**Response Matrix**

Cornerstone House of Refuge Apostolic Church  
2375 St Laurent, Ottawa

February 28, 2023

PARKING DETENTION - 100 YEAR + 20%

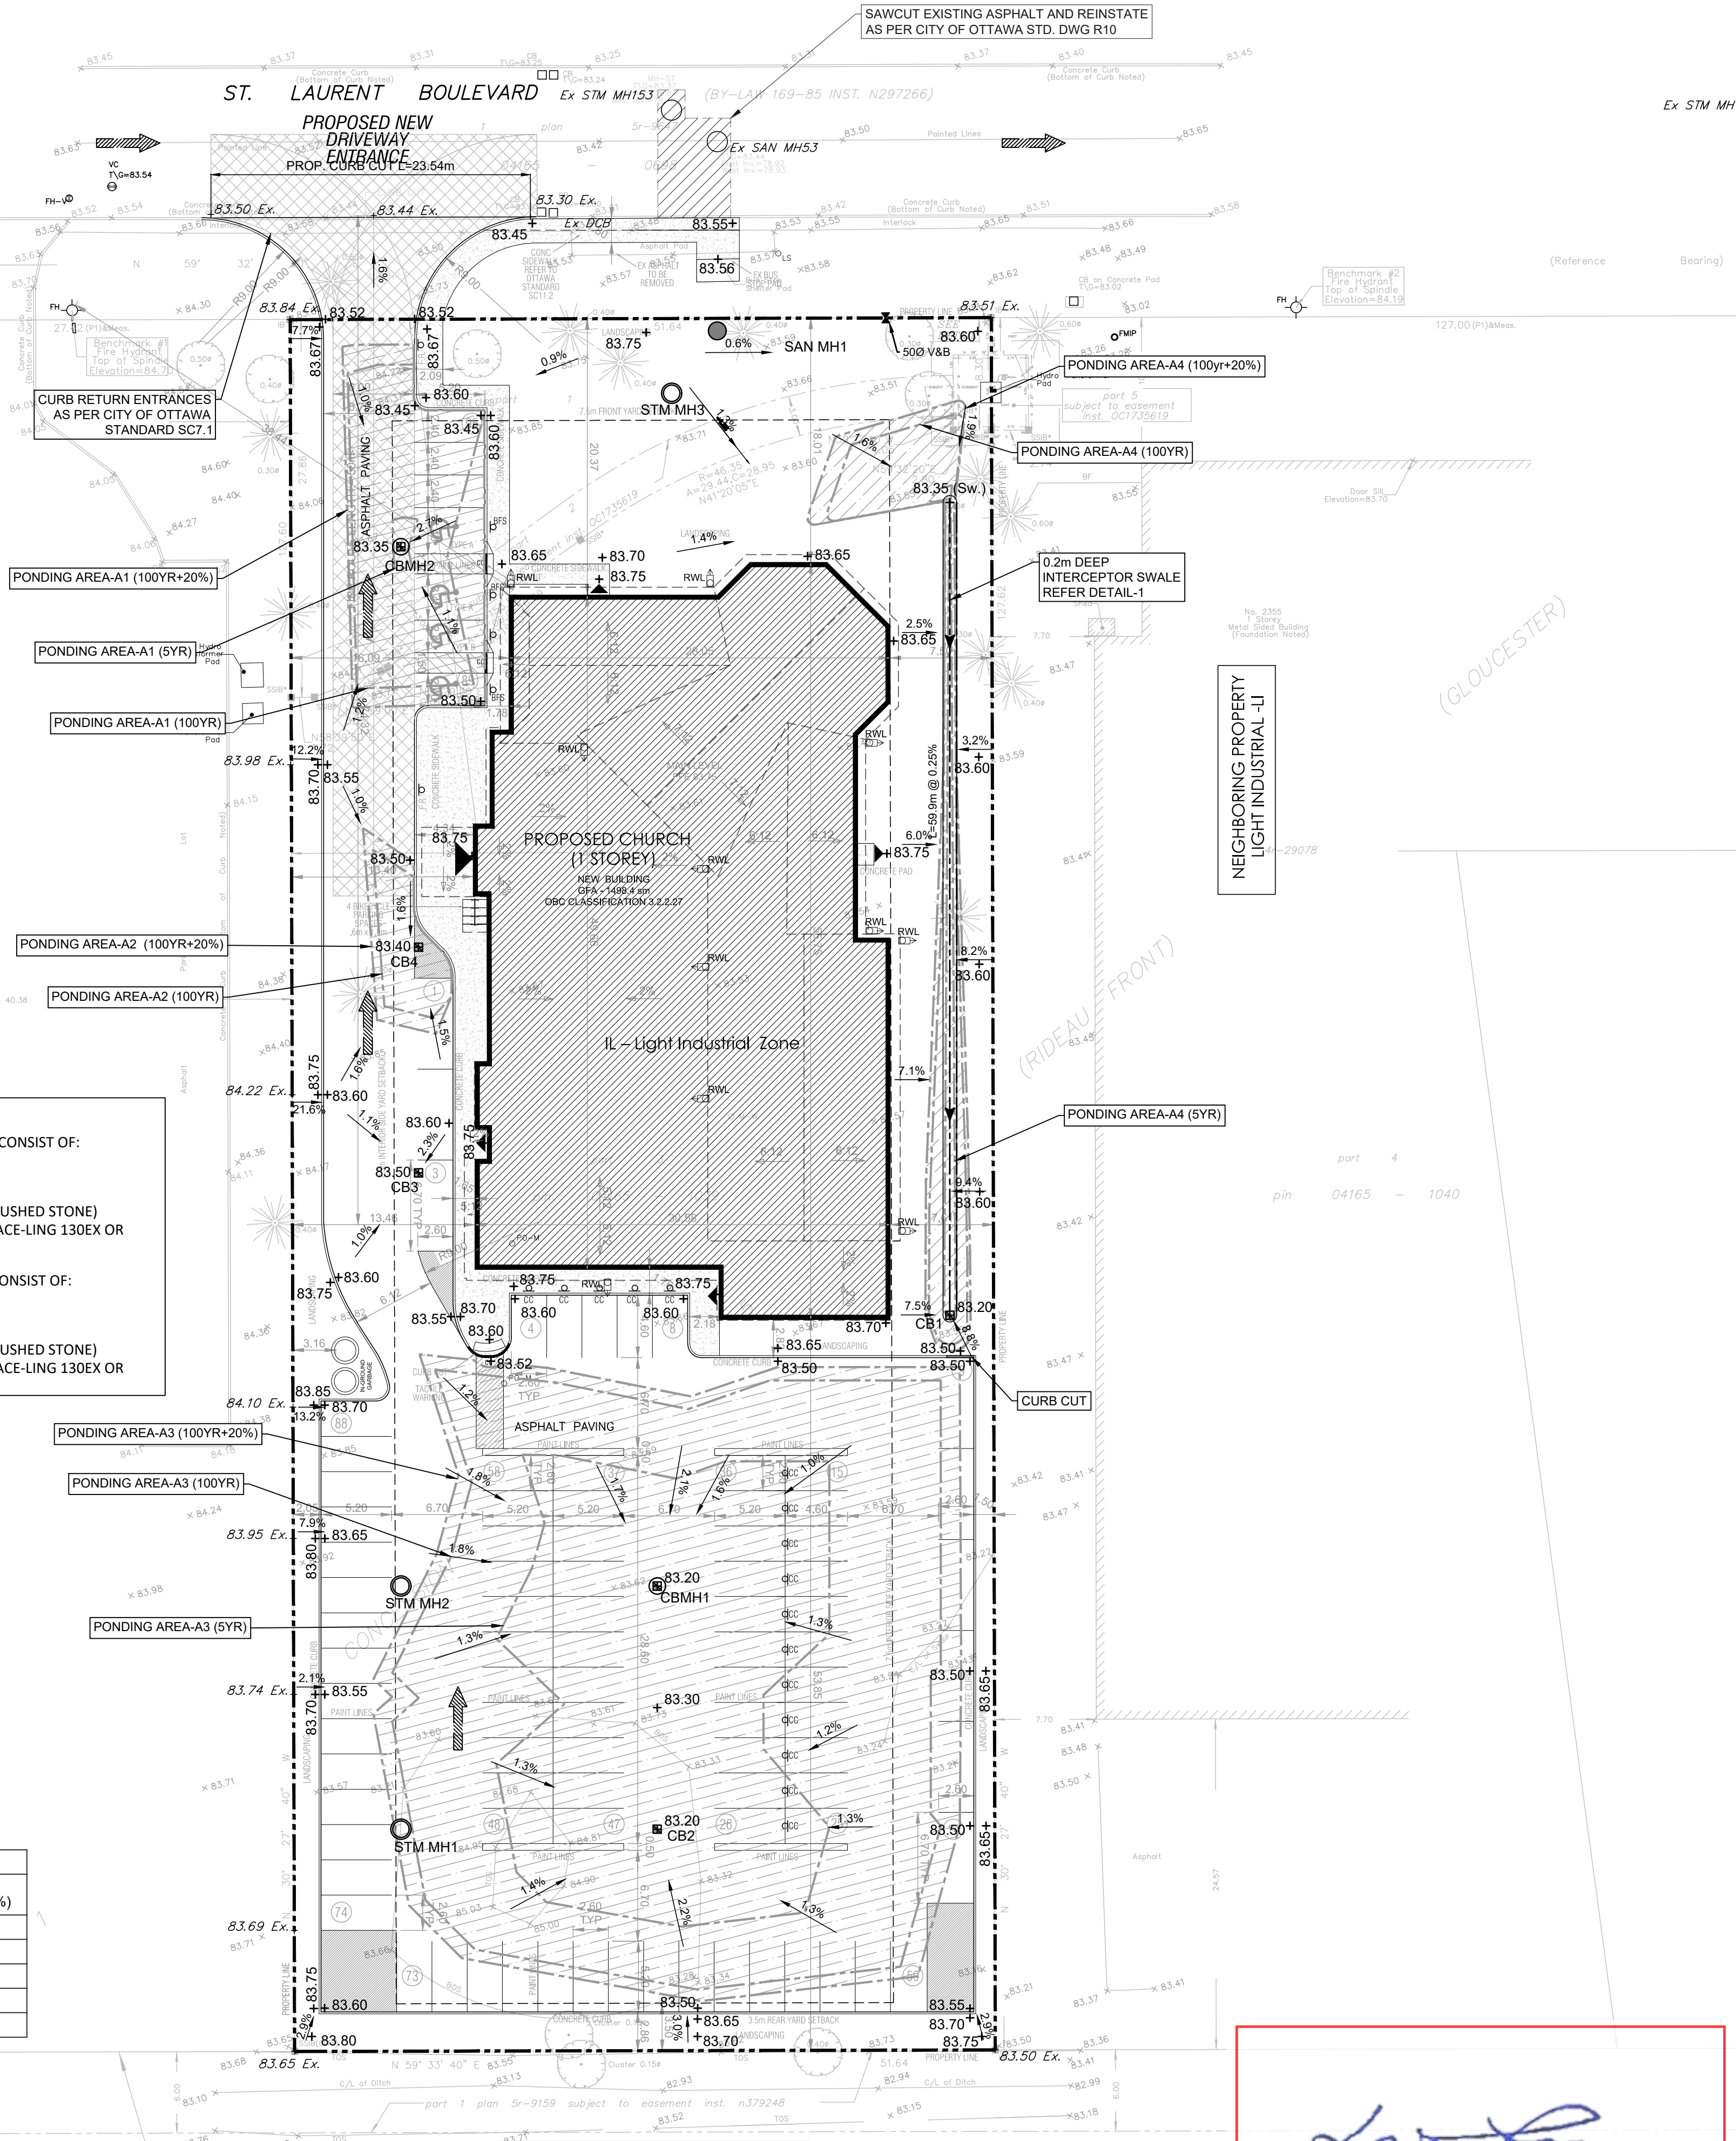
<b>Engineering Drawings (Bruce Bramah):</b>	
<p>A. Site Grading Plan, 20037_SP4, prepared by Reinders + Law LTD, dated 2/14/2022, revision 1, dated 12/13/2022</p> <p>A1. Please ensure all grade arrows have an associated percentage</p> <p>Outstanding. Exterior grades within 2.0m from the building shall have a slope at or greater than 2% as per the section 6.4.4 of the Geotechnical Investigation report. Please revise.</p>	<p>Slopes are revised to the maximum available. See revised grading plans</p>
<p>A5. Please add note regarding City of Ottawa Standards R10 and SC7.1 for the works within the ROW.</p>	<p>Note added.</p>
<p>A6 The perimeter of the site appears to have areas which are uncontrolled. Please revise the post development drainage area and associated SWM calculations.</p>	<p>Uncontrolled areas are marking in post development drainage plan and SWM calculations are revised accordingly.</p>

<p>A7 Please clarify the emergency overland flow elevation for Ponding Area A3 and A4. Please note, there must be a minimum 0.15m clearance between the spill elevations and the grade adjacent to the building.</p>	<p>Grades are revised and overland flow elevations are 0.15m below the spill and grades adjacent to building.</p>
<p>B. Site Servicing Plan, 20037_SP3, prepared by Reinders + Law LTD, dated 2/14/2022, revision 1, dated 12/13/2022.</p> <p>B4 The 200mm connection to the 300mm sanitary main requires a maintenance hole as per SDG 4.4.4.11. Please revise the service location to the existing SAN MH53 or provide a new MH at the proposed location</p>	<p>SAN service connection moved to existing SAN MH53 location.</p>
